From: Sian Eggington [REDACTED]
Sent: 11 November [REDACTED]
To: Sian Eggington
Subject: FW: Further Information Required on Your Ref: PP-08256561 Our Ref: FP/236/19/HH
Attachments: We sent you safe versions of your files; 1916-02a 03.pdf

**DRAWING SCALE:** 1:100 @A3  
Proposed Elevations  
DATE: Oct 2019  
DRAWN: A. H. Sutcliffe  
DRAWING: 1916-I-02

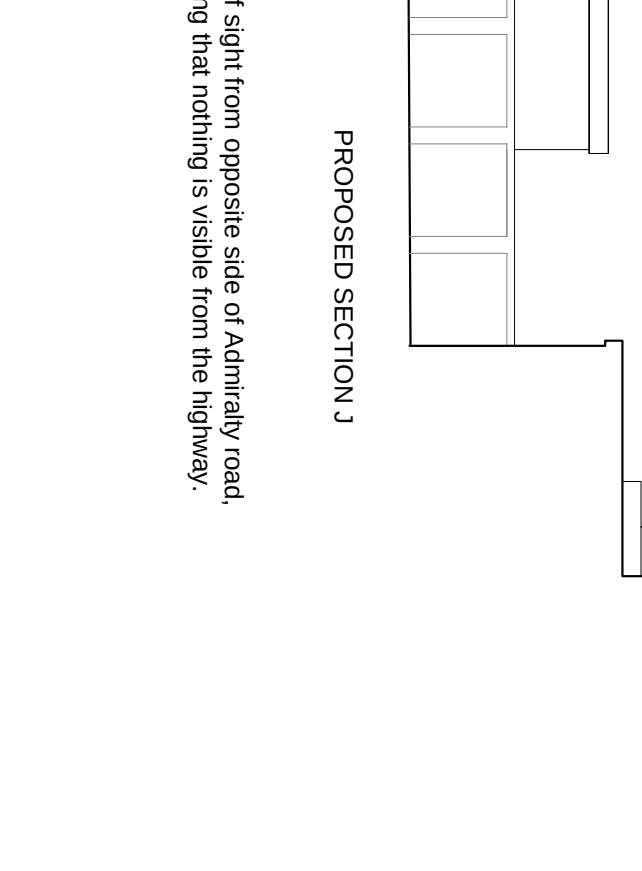
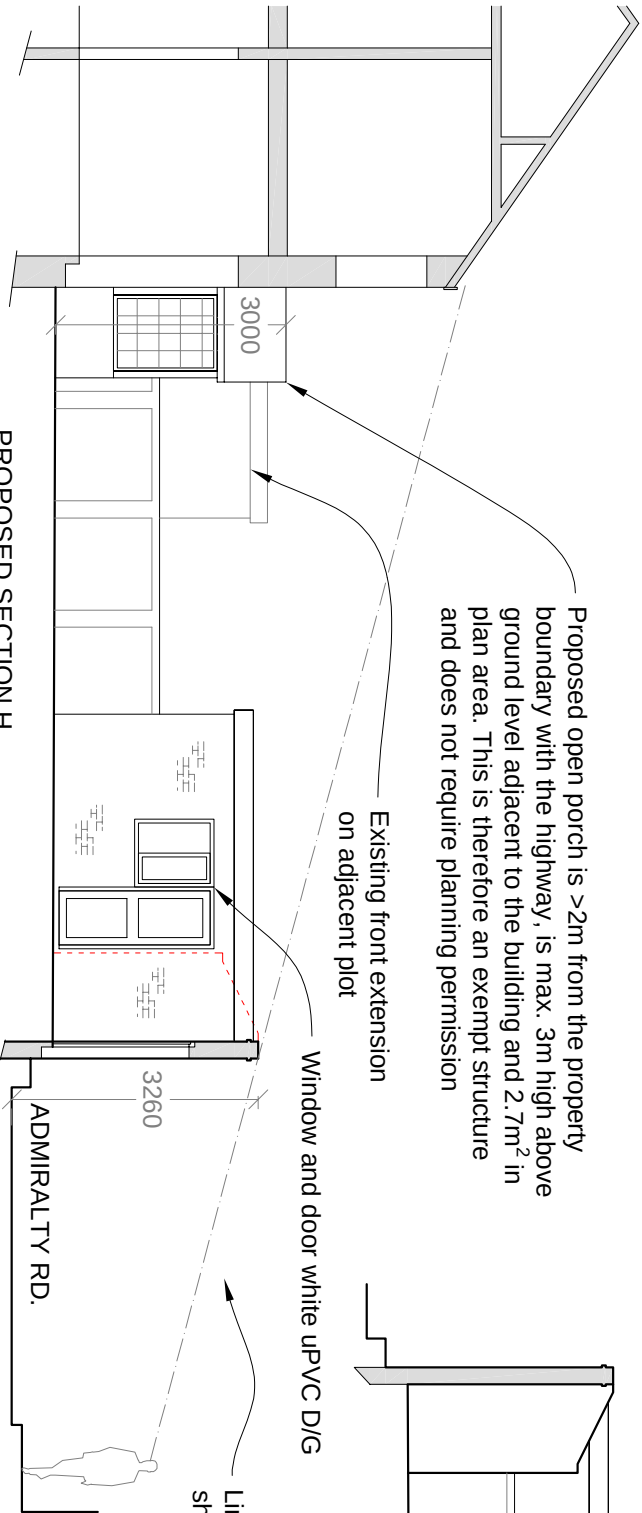
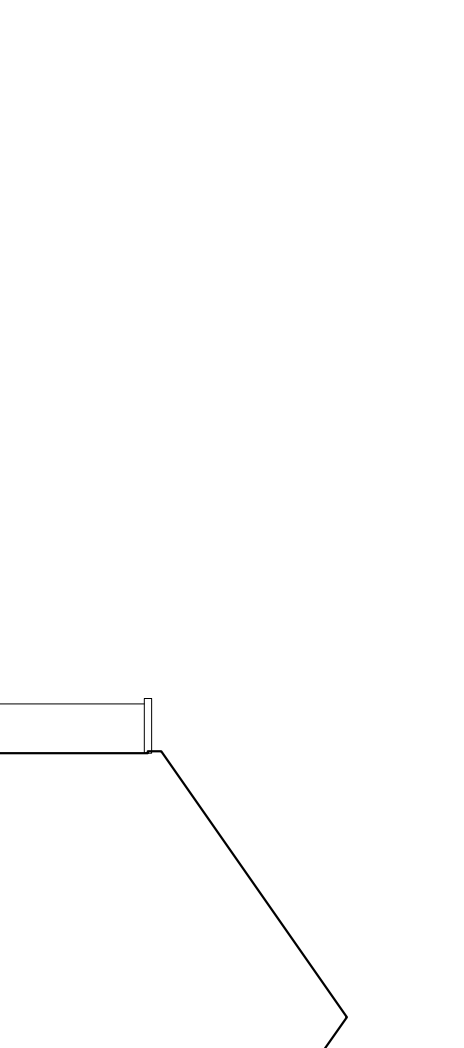
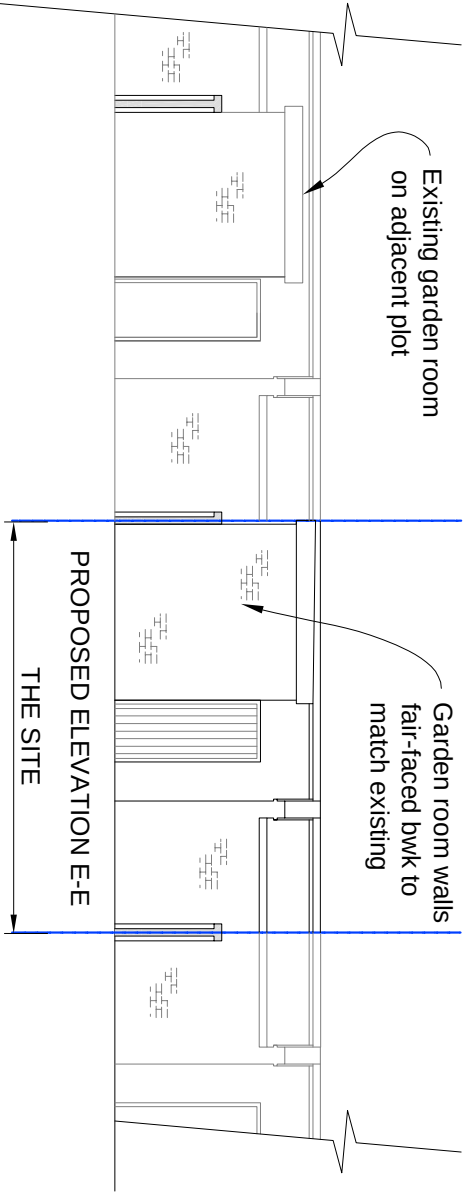
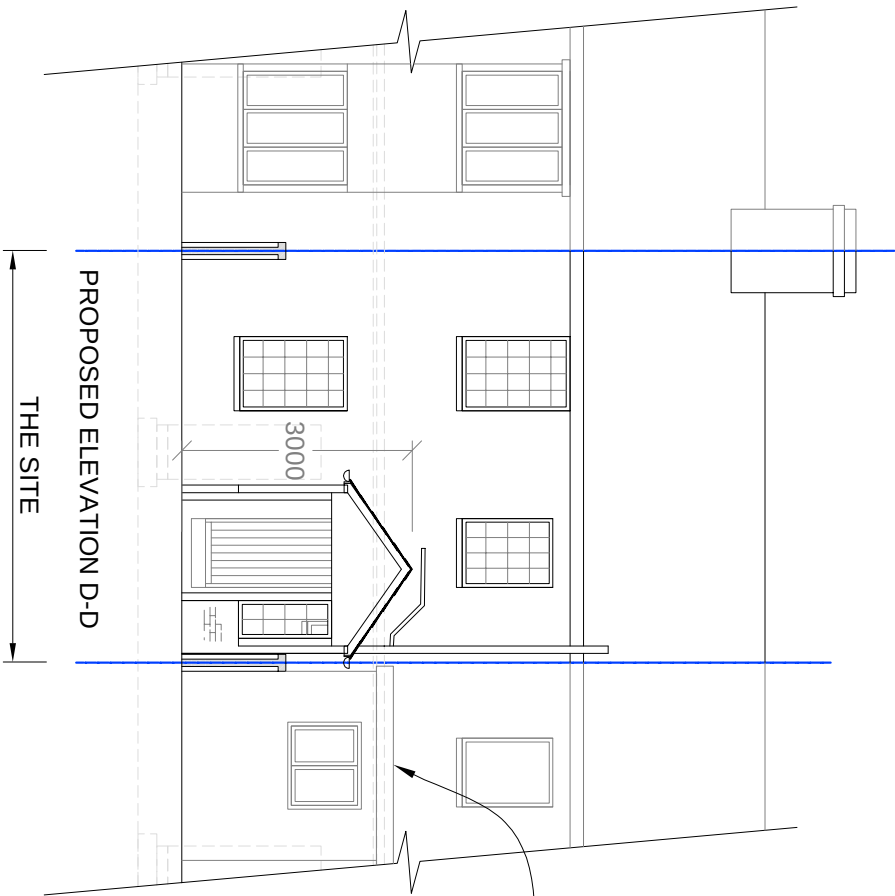
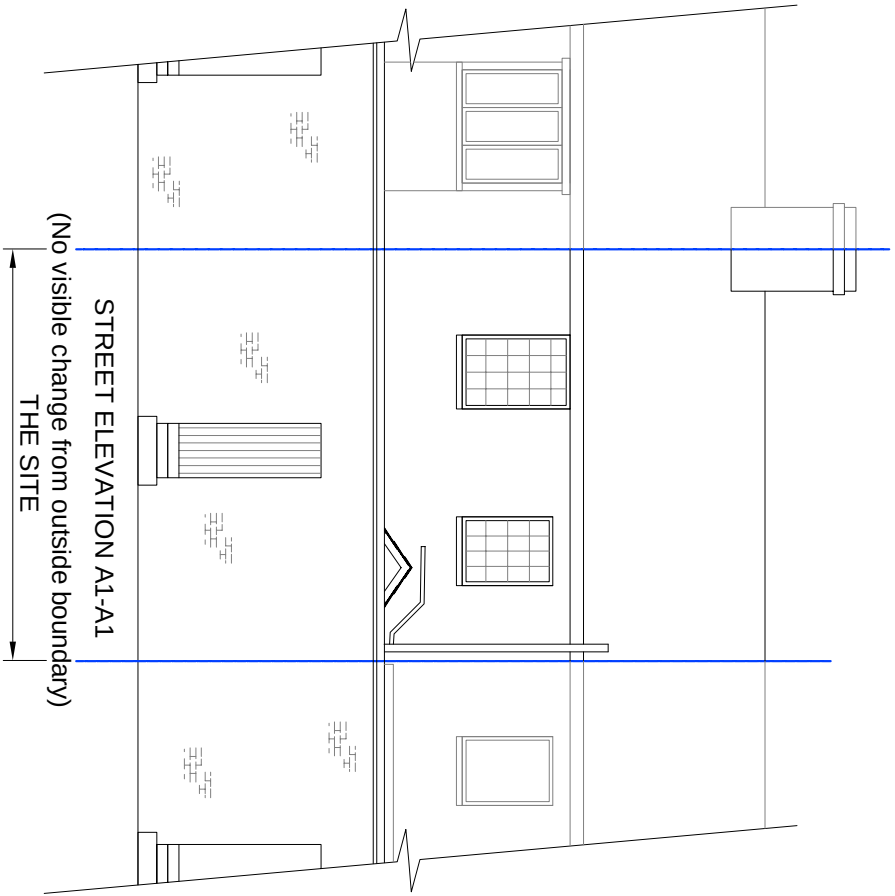
The proposed garden room cannot be seen from the road, so no elevation is shown. The other three elevations are shown on plan 1916-1/02

DRAWING SCALE: 1:100 @A3
Existing and Proposed floor plans
DATE: Oct 2019
DRAWN: A. H. Sutcliffe
DRAWING: 1916-I/03 REVISION: A

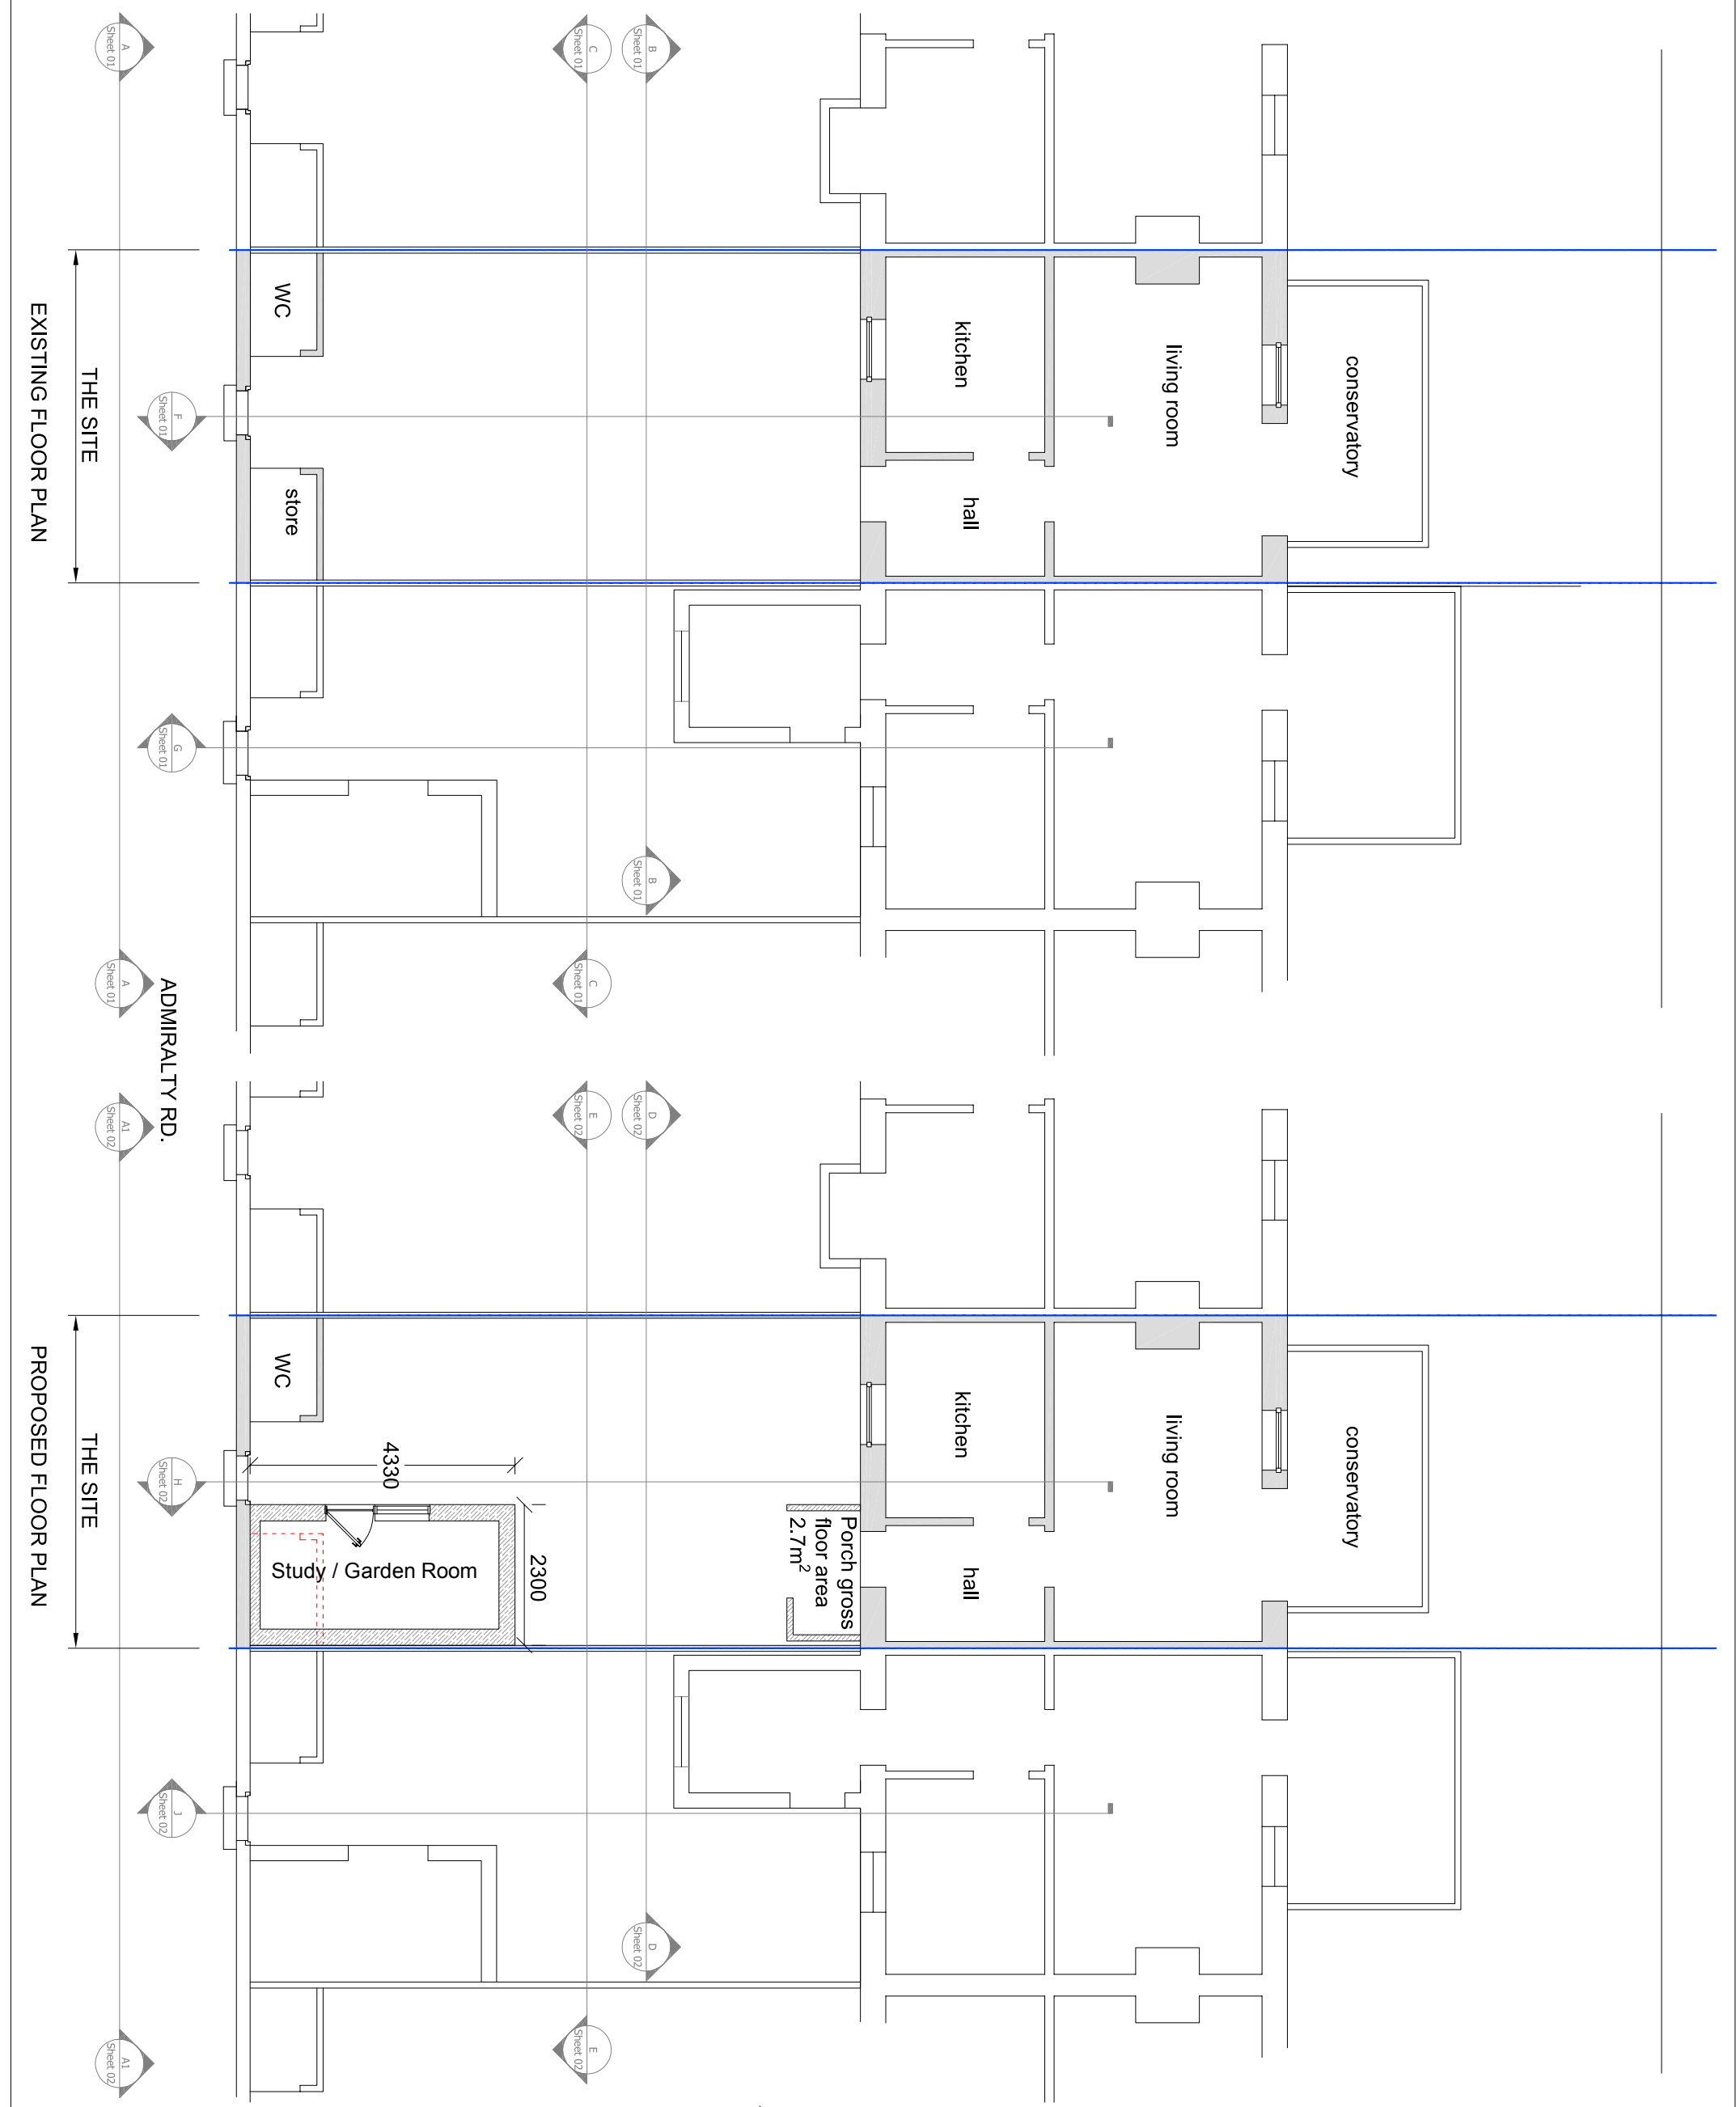
Further to your letter and our conversation, please find an amended drawing attached with room names added.
